**Cover Letter to Submission - State Significant Development
(SSD-94439711) – Enfield Material Recovery Facility Expansion
40-42 Madeline Street, Strathfield South**

Strathfield Council Draft Submission to State Significant Development (SSD-94439711) – Enfield Material Recovery Facility Expansion – July 2026

Figure 3. Noise Wall Locations

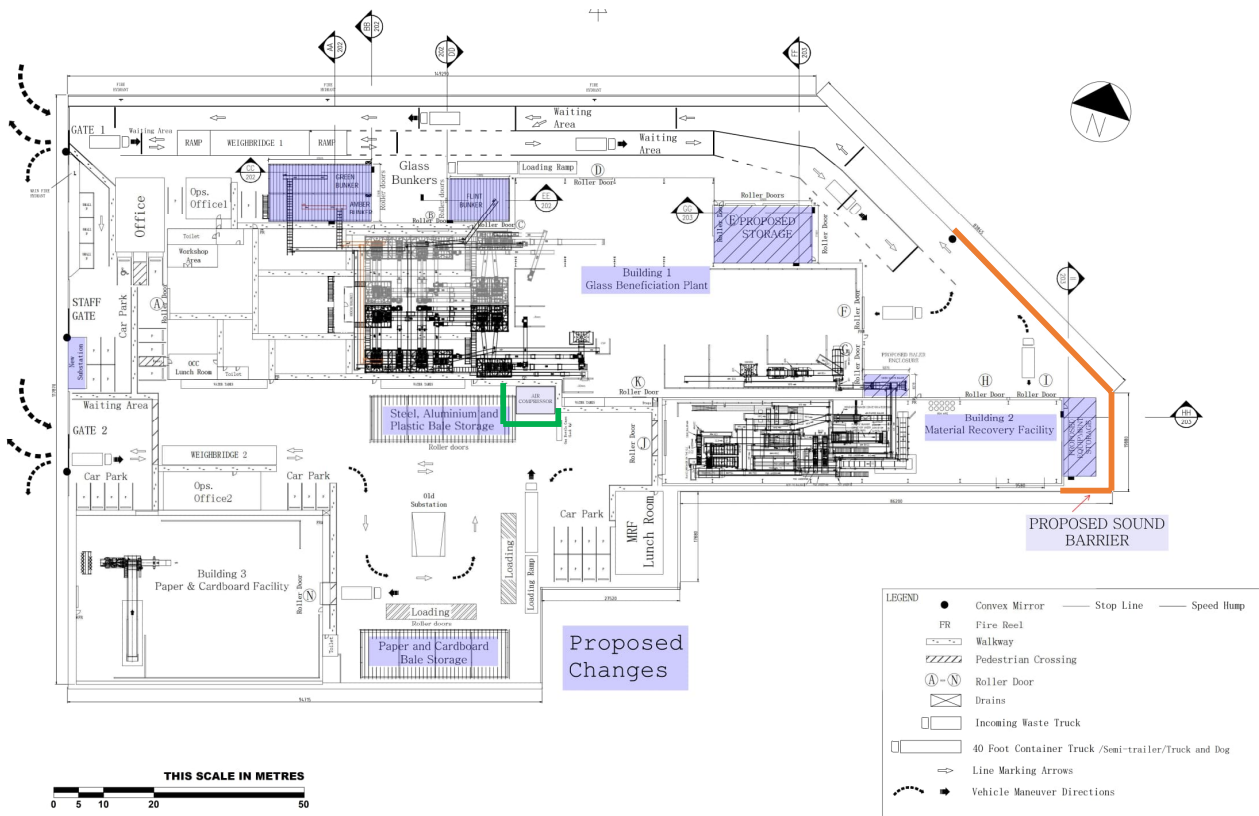
The proposed items to be removed are identified in the report as MM05, acoustic lining to a building, and MM09, acoustic lining to another building (refer to Figure 1 below for more details). The supporting justification to remove approved noise control measures is based on flawed reasoning that is not supported.

- The justification for removal is based on the structures at the neighbouring site, 84 Madeline Street, currently occupied by Aussie Skips. The applicant is not in control of those noise walls/barriers & their maintenance currently in place at Aussie Skips.
- The noise modelling did not include the impacts of the loss of the shielding structures.
- Mitigation measures must be based on the applicant's ability to control them as compliance will depend on third party structures remaining indefinitely and being maintained indefinitely.
- The report has not demonstrated that compliance can still be achieved if the adjacent site changes ownership, operations or building configuration.

MM05	compressors to 80%. Install a minimum of 1500 sqm of acoustic material on the inside of the building, to line the walls and the upper part of the walls. The lining should provide an NRC of not less than 0.75.	No longer required as noise emissions from the site have been reduced due to the changes at the adjacent Aussie Skips site. Not required
MM09	Install a minimum of 1000 sqm of acoustic material on the inside of the building, to line the walls and the upper part of the walls. The lining should provide an NRC of not less than 0.75. Review and repair all facade and roof	No longer required as noise emissions from the site have been reduced due to the changes at the adjacent Aussie Skips site. Not required

- The removal of internal lining is again based on external factors that the applicant does not control rather than reducing the noise source.
- The noise modelling done for mobile noise sources at 100% load for 50% of the time on average is not necessarily a conservative approach. Data should replicate a worst-case scenario where trucks are queuing for periods of time.
- The report fails to show whether peak hour was included in the assessment.
- The report does not clearly explain what noise sources are fixed and mobile.

Accordingly, Council recommends that the applicant prepare and submit an amended Noise Impact Assessment that addresses the matters outlined above, including updated baseline monitoring, contemporary traffic data, revised acoustic modelling and an assessment of the effectiveness of the existing noise shielding structures. The revised assessment should also reconsider the appropriateness of removing any existing noise management or monitoring requirements.
